State of Washington
DEPARTMENT OF FISH AND WILDLIFE

August 21, 2024

SUBJECT: RE: CU-24-00003 Schnebly Coulee Solar Farm - Re-Notice of Application

Figure 7.1. Conservation easements adjacent to, and within, the Project Area at the Schneibly Coulee Solar Energy Project, Kittitas County, Washington.

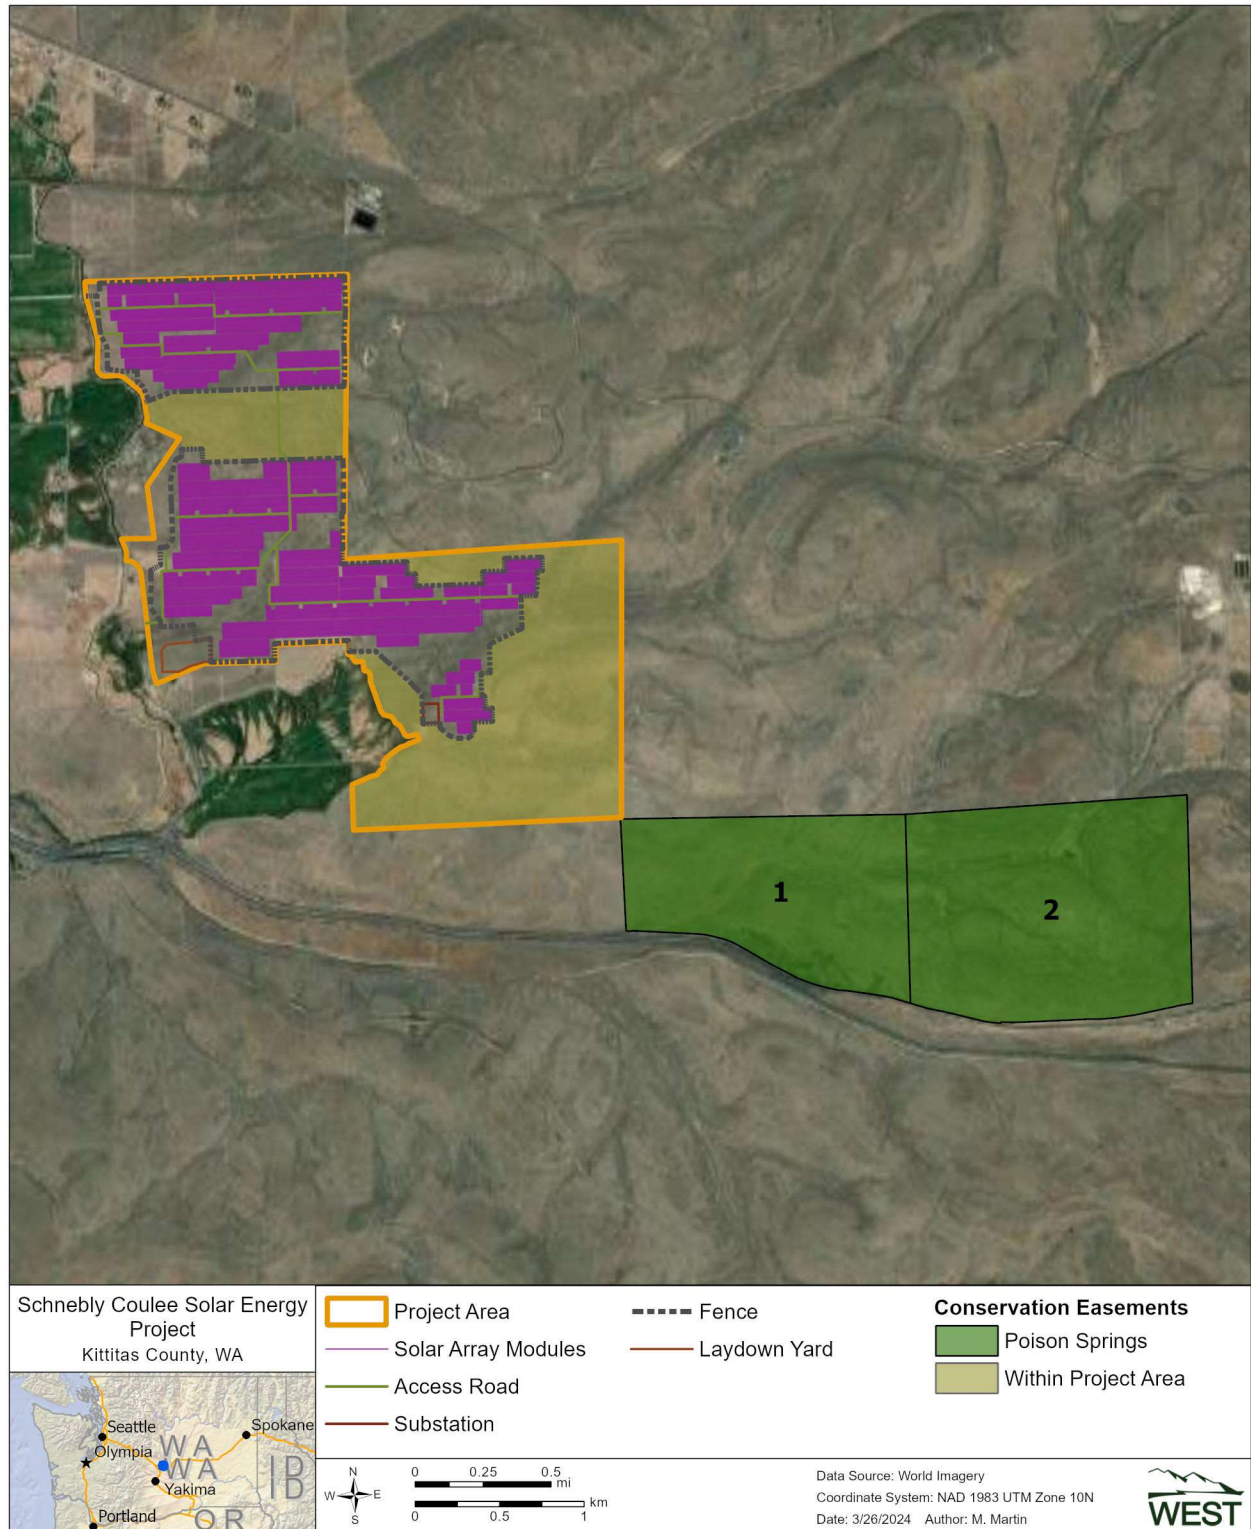
One potential discrepancy noted by WDFW was the inclusion of contingency panels in a portion of the proposed conservation easement (CE) highlighted in red from Figure 7.1 of the Habitat Management Plan below. The contingency panels in question are in C-503 and C-504 in the "Overall Proposed Conditions" in pink below. The applicant clarified that this is correct, and the area has been identified in the contingency plan but will only be fenced if the contingency plan is adopted. WDFW acknowledge these changes and requests that a final discussion about the Habitat Management Plan occur once the final site layout is confirmed.
